Gatwick Airport Northern Runway Project

Third Change Application Report

Application Document Ref: 10.60

PINS Reference Number: TR020005

**Project Code:** 41700-XX-B-LLO-GA-200152

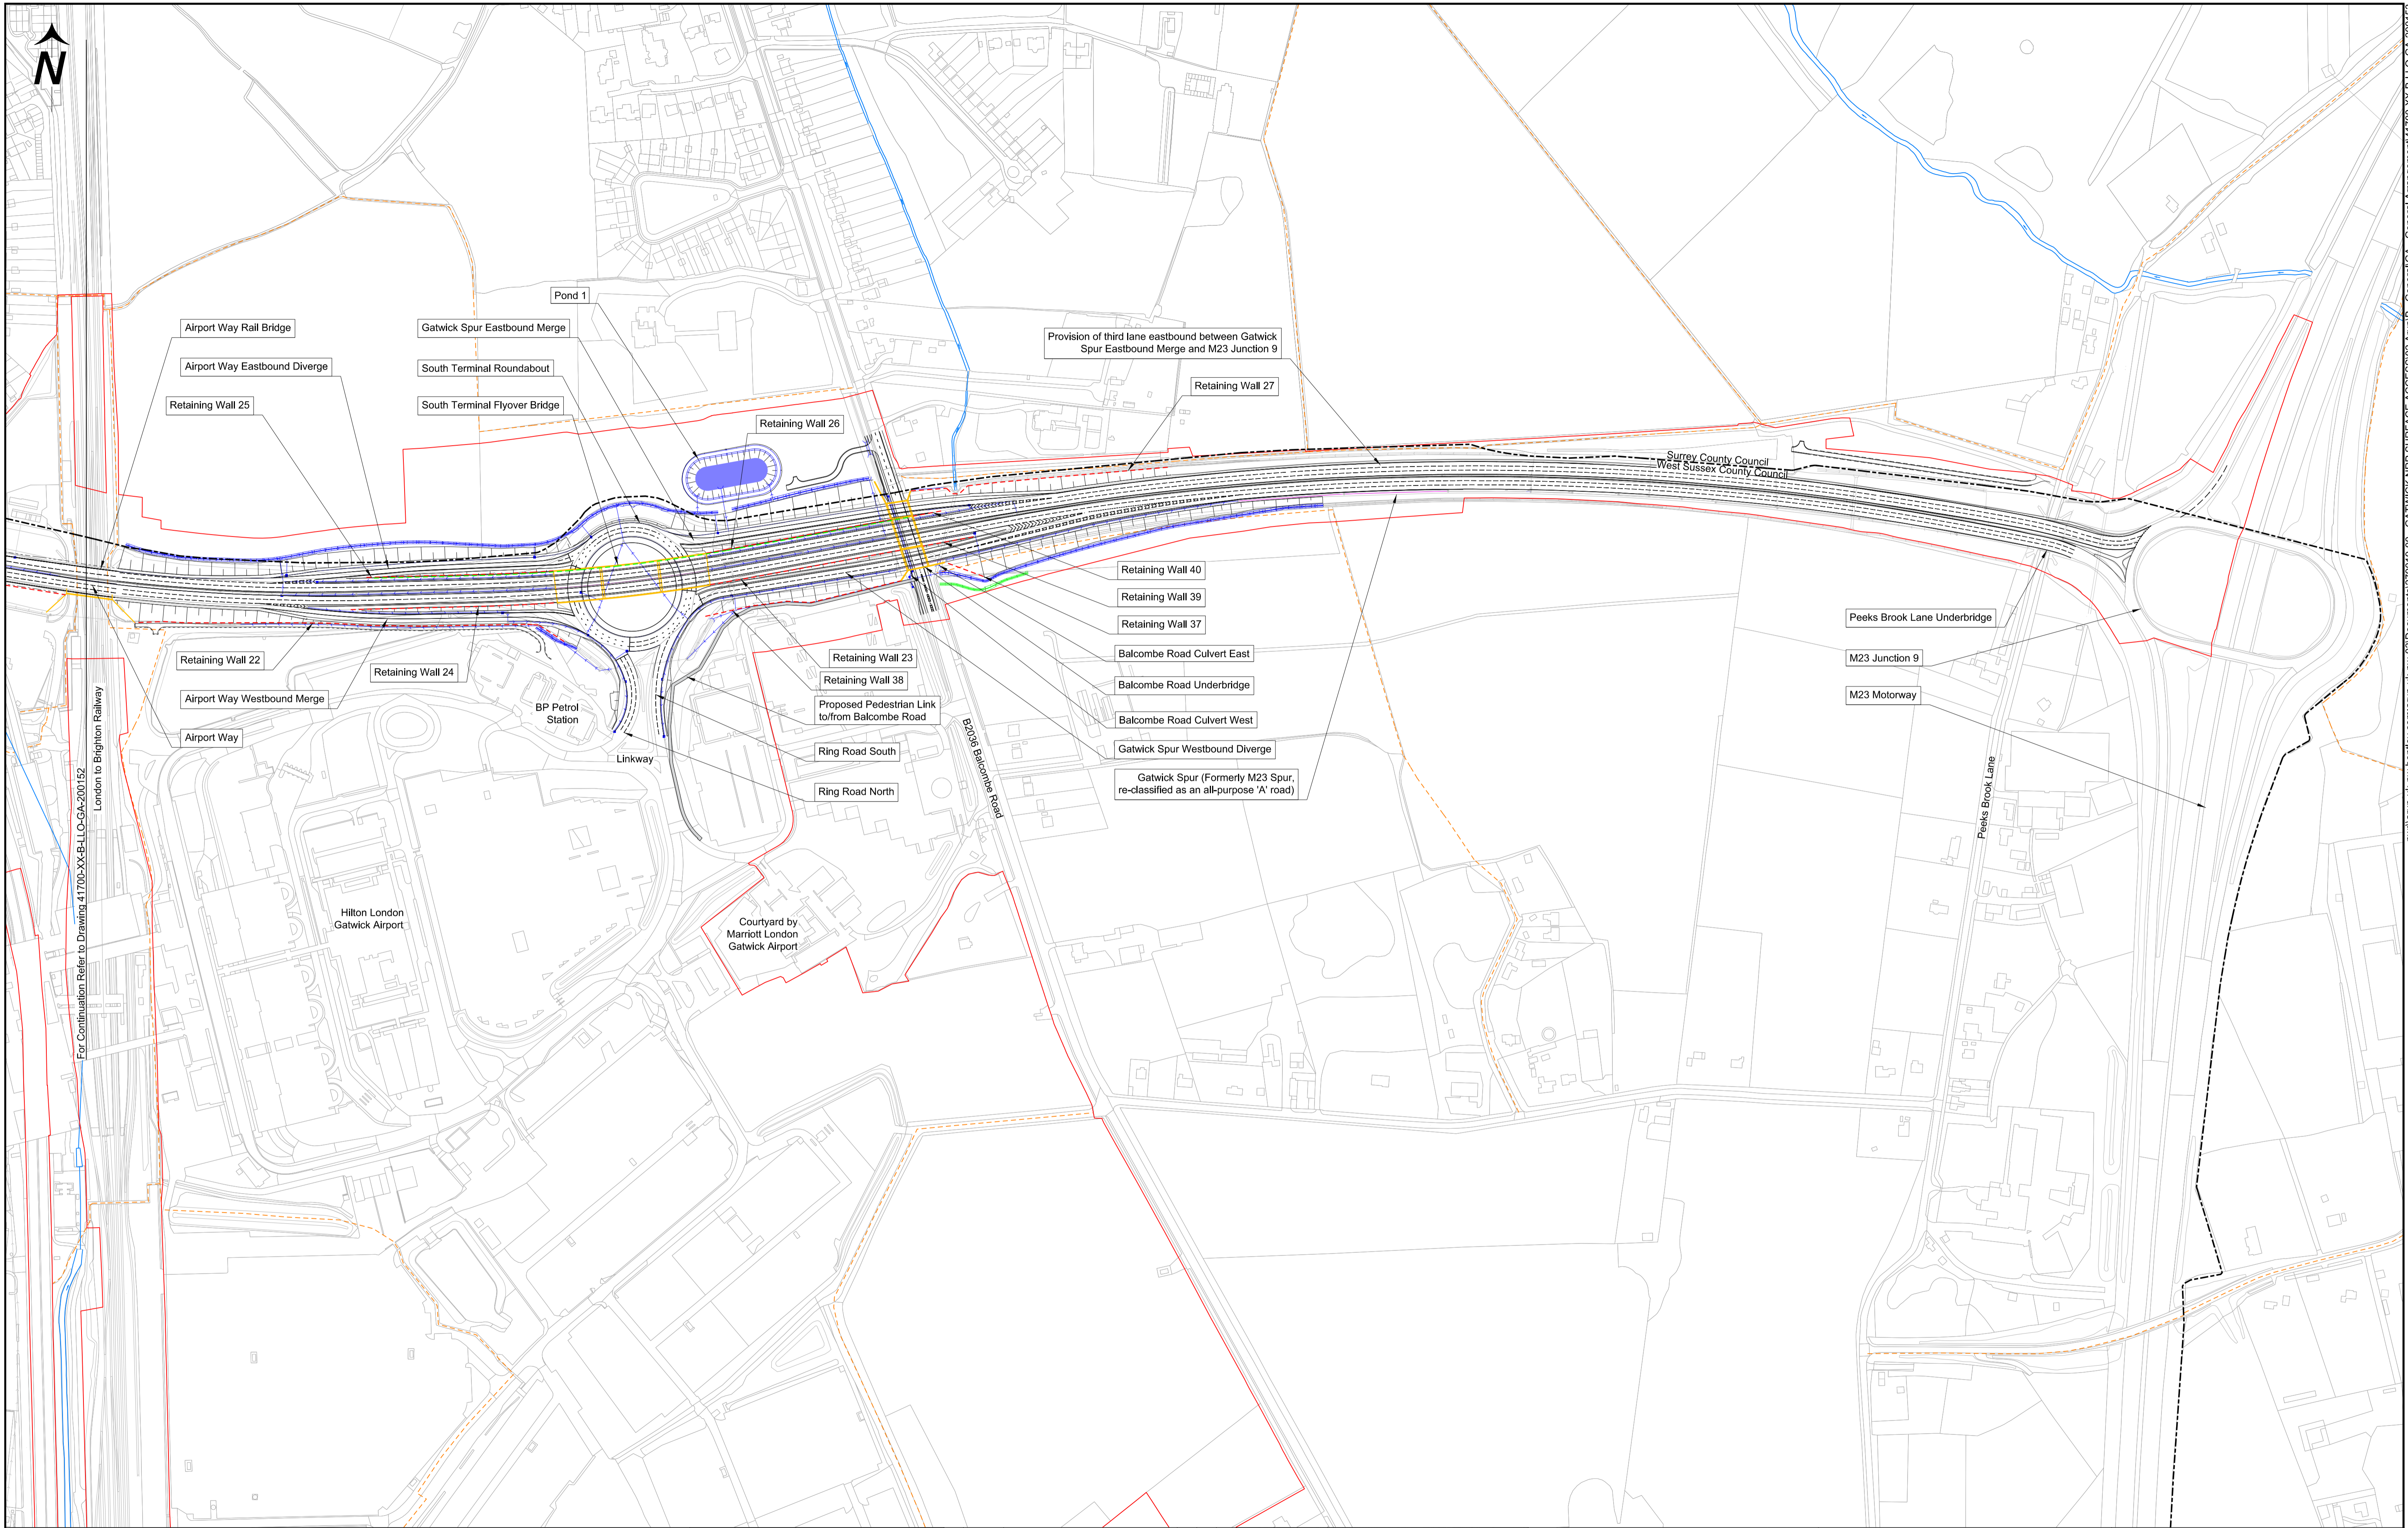
- 1.2.2 Project Change 5 relates to a very minor extension to the Order Limits to incorporate additional land (comprising 0.175ha in size) at the Holiday Inn to facilitate the construction of a temporary access point, a temporary bus parking layby, temporary traffic management measures and associated drainage provisions. This additional land area is very small compared to the overall footprint of the Order Limits.

- 2.2.1 As part of the DCO Application, as submitted, works are proposed to widen and realign Longbridge Roundabout junction under Work No. 37 of the **Draft DCO** (Doc Ref. 2.1 v9) located immediately east of the Holiday Inn. To facilitate the junction improvement works, land at the Holiday Inn is identified as being required on a temporary basis to enable the junction's construction works and part of the limits of deviation for the permanent junction works. The land required on a temporary and permanent basis is shown on Inset Sheet 1 of the **Land Plans** [[REP5-015](#)].

- 2.2.3 Project Change 5 comprises a very minor extension to the Order Limits to incorporate additional land (comprising 0.175ha in size) in order to facilitate:

- A temporary access point from the A217 to the Holiday Inn, north-west of the hotel's existing access;
- A temporary bus parking layby, within the Holiday Inn premises, able to accommodate 4 buses;
- Temporary traffic management measures to restrict A217 southbound users from turning right into the temporary access point; and
- Associated drainage provisions.

2.2.5 The temporary access arrangement is for access only, for one-way traffic, in that vehicles would enter the Holiday Inn site from the A217 northbound from Longbridge Roundabout, travel along the hotel's internal road network and then exit to the south via the existing access onto Povey Cross Road. The access is 10.5m wide at the interface with the A217, reducing to 6.5m to accommodate the required vehicle tracking.

- 2.2.6 The temporary bus parking layby would be located north of and in front of the hotel's entrance, designed to provide a waiting area for up to four buses. It has been designed to accommodate four standard rigid bus (with a size of L12m x W2.5m x H3.069m) however GAL understands that it is specifically required by the Relevant Affected Persons to serve as a waiting area for Hoppa Buses, to allow users to access the Airport. Upon completion of the works, the temporary layby would be removed and landscaping would be restored as per the existing provisions.

- 2.2.7 The construction of the bus parking layby would require the temporary removal of the eight existing flag poles within the Holiday Inn's estate. The flag poles would be reinstated upon completion of the works.

- 2.2.8 The temporary traffic management measures, which are required to restrict A217 southbound road users from turning right into the temporary access point, will be confirmed at the detailed design stage. Such measures may include temporary modifications to the central road markings (hatched area) on the existing A217 to restrict road users from crossing and/or the provision of temporary bollards in the central hatched area.

- 2.2.9 The associated drainage provisions required as part of the design of the temporary access would include an outfall from the Holiday Inn's temporary linear drain into the existing drainage network, together with an extension to a carrier pipe and new headwall to the proposed outfall to the existing ditch.
